**KIRKLEES METROPOLITAN COUNCIL
INVESTMENT & REGENERATION SERVICE**

**DELEGATED DECISION FOR APPLICATION FOR CERTIFICATE OF
LAWFUL DEVELOPMENT**

Reference no.: 2024/CL/92100/W

Description: Certificate of lawfulness for proposed erection of
single storey side extension

Drawing Number  
 24\_814\_101

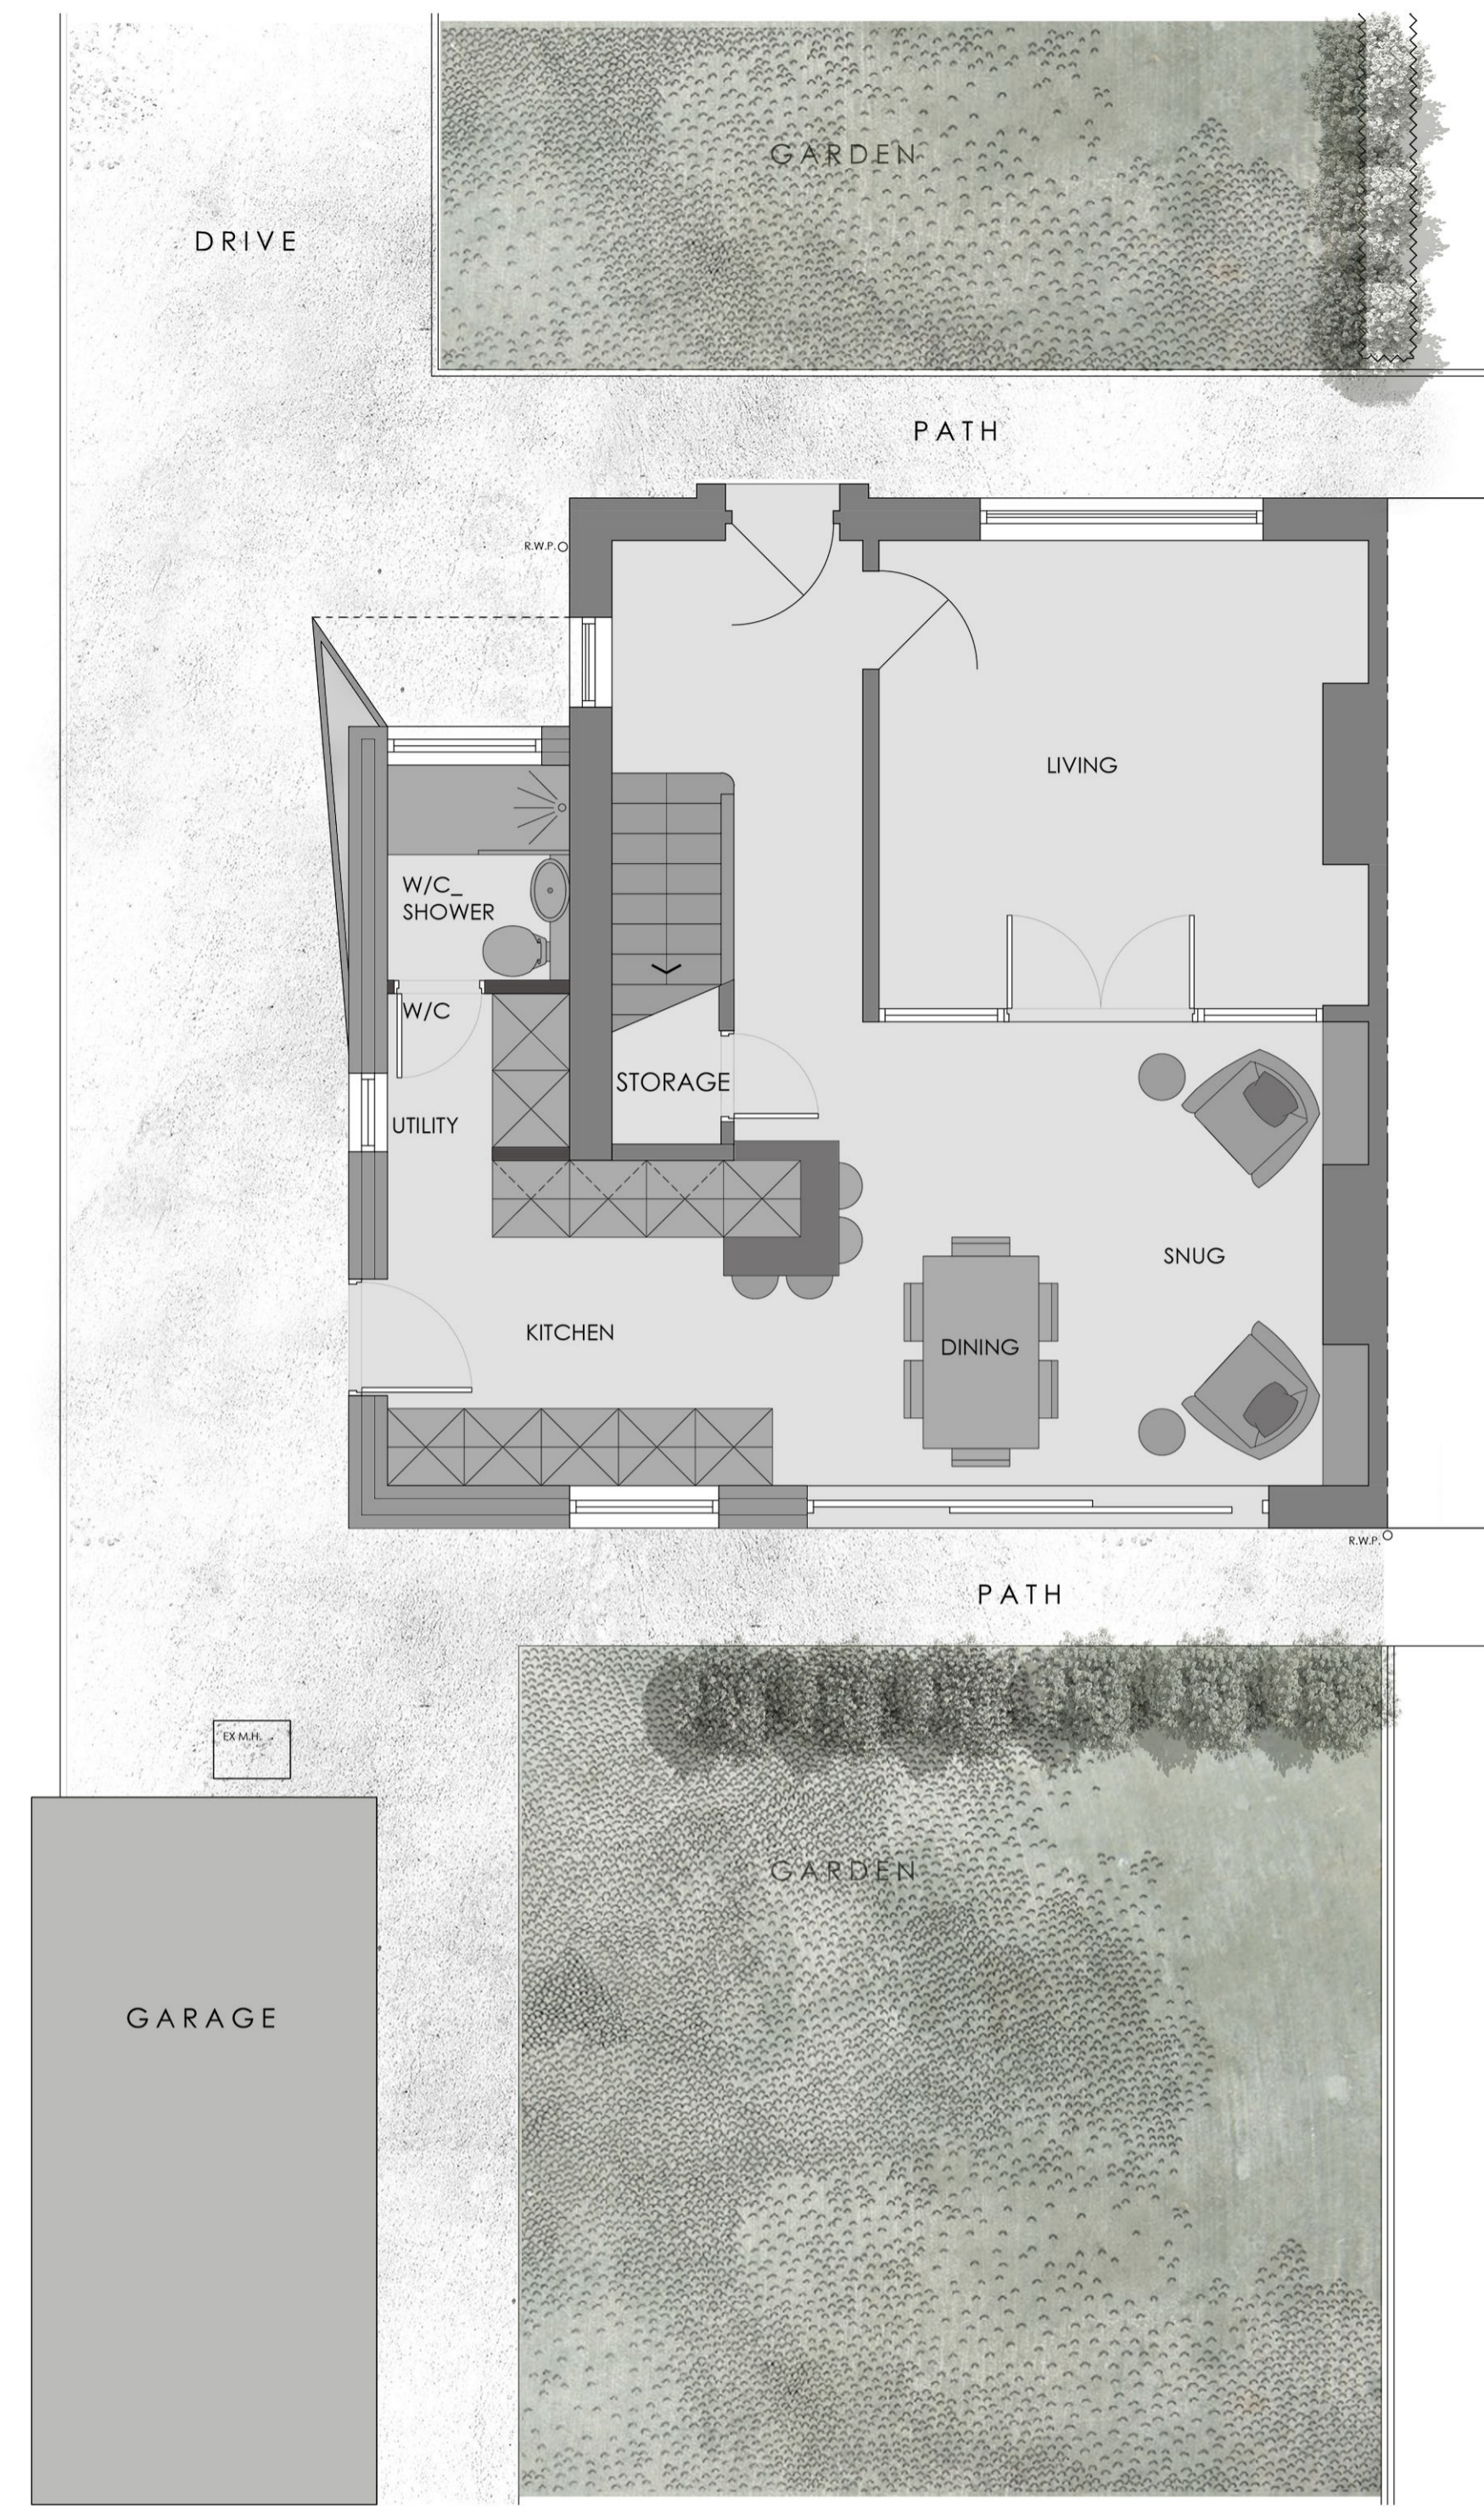
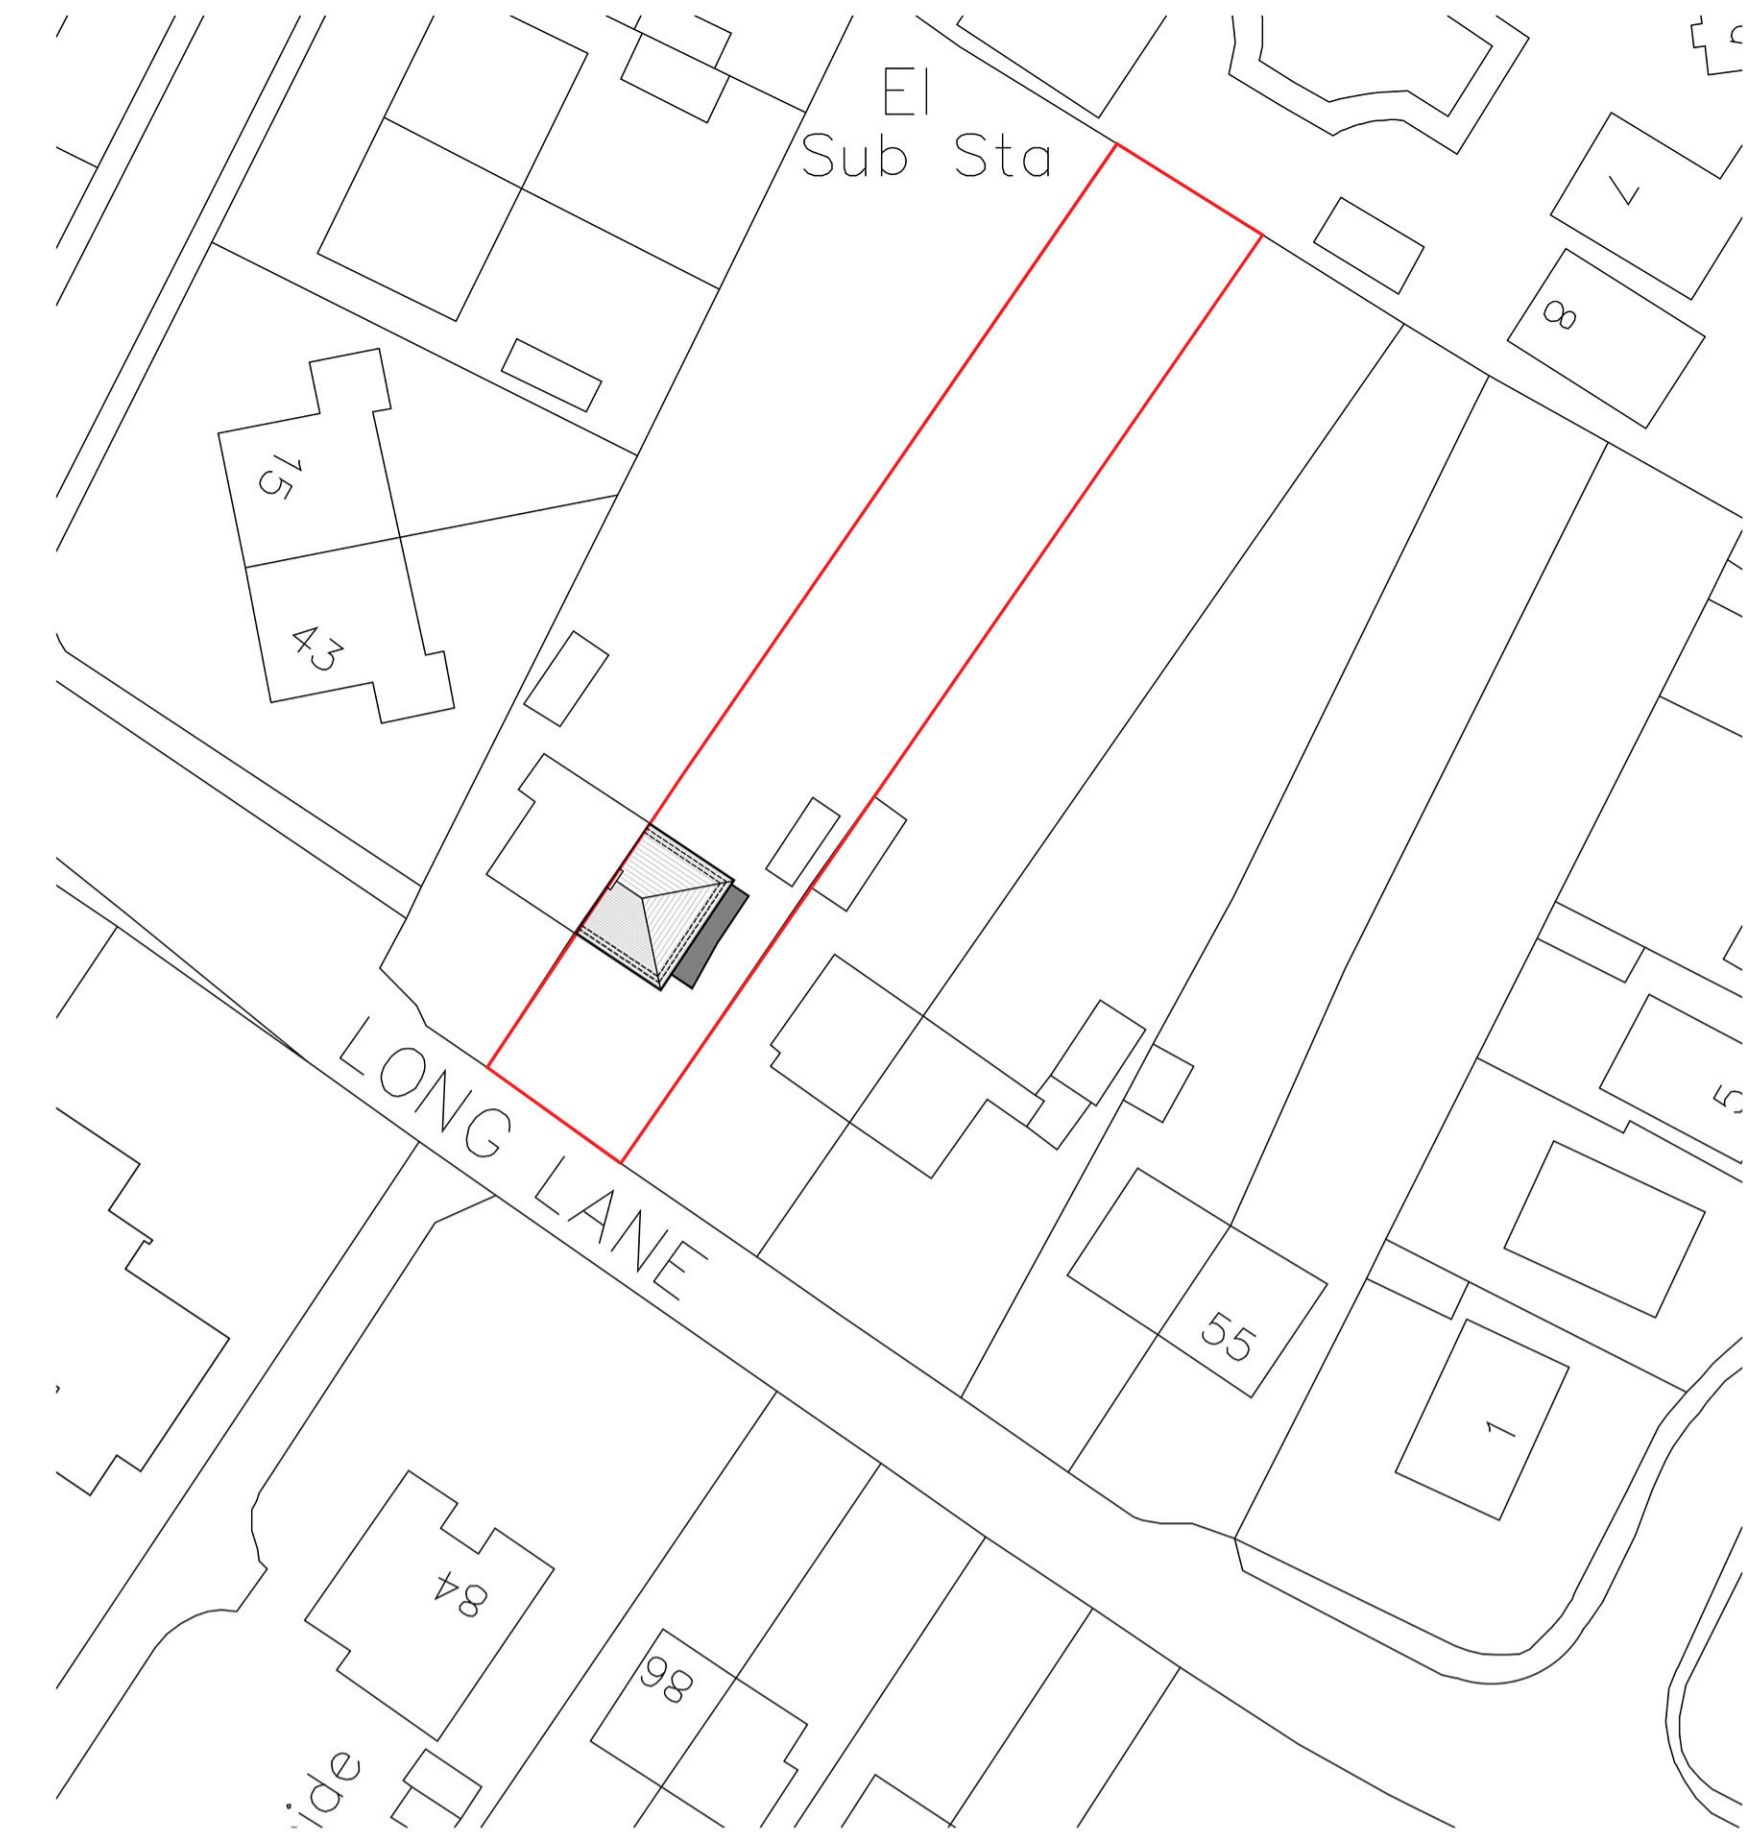
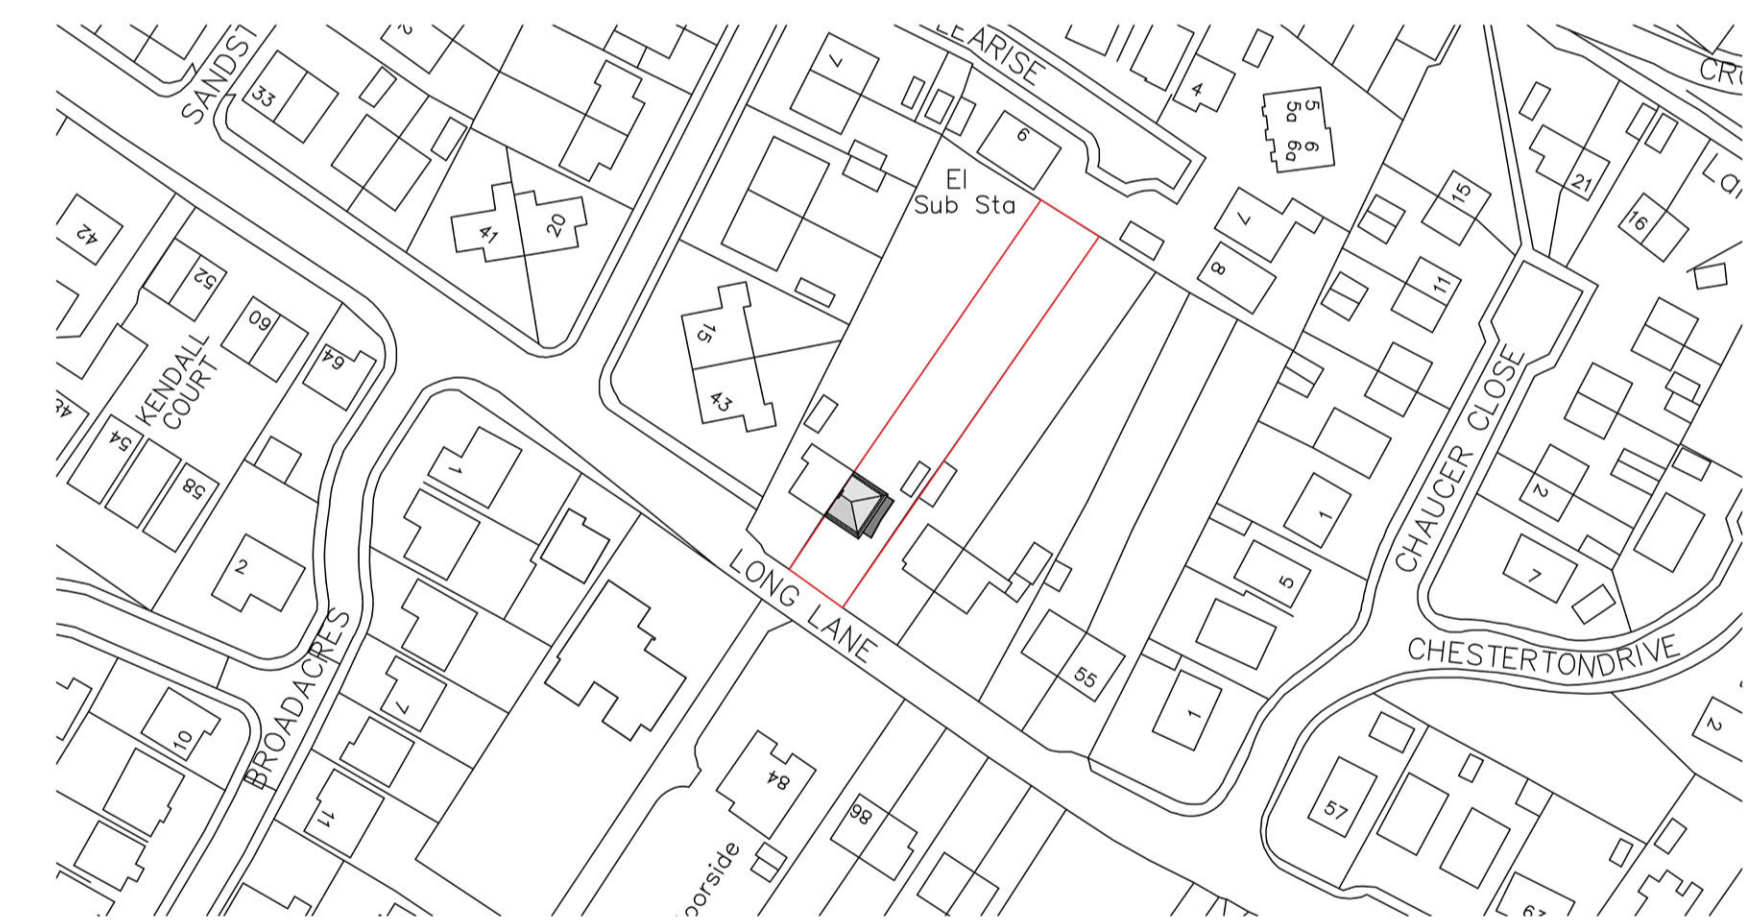
The maximum projection is 2.0m from the original dwelling (flared element), the approximate length of the extension is 7.2m, with the total height of the flat roof being 3.1m. The addition would be 3.3m to the closest boundary.

Comment: The highest part of the extension would not exceed the height of the highest part of the roof of the existing dwellinghouse.

Comment: The height of the eaves would not exceed the height of the eaves of the existing dwellinghouse.

Comment: The extension does not extend beyond a wall which forms the principal elevation. It does extend beyond a wall that forms a side elevation of the original dwellinghouse but this does not front a highway. The original dwellinghouse consisted of a small side projection set 5 metres from the principal frontage of the property at a width of less than 1 metre and approximately 2 metres in height. While this projection has a elevation facing towards the principal elevation of the main part of the house, it is considered the scale and appearance of this elevation is inconsequential in terms of presenting a frontage of the dwellinghouse and as such is not considered to be a wall forming part of the principal elevation of the original dwellinghouse.

Comment: The extension is not within 2 metres of the boundary of the curtilage of the dwellinghouse.

Comment: The extension projects beyond a wall forming a side elevation but does not exceed 4 metres in height. The proposed extension is single storey and does not have a width greater than half that of the original dwellinghouse.

Comment: The original dwellinghouse appears to have an existing side enlargement, as visible in historic mapping, the proposal would however, not exceed the limits set out in sub-paragraphs (e) to (j).

Comment: The construction materials would be of a similar visual appearance to the existing dwellinghouse in all aspects, including the changing of the openings to the rear of the property. There are no new windows proposed to upper floor side elevations.
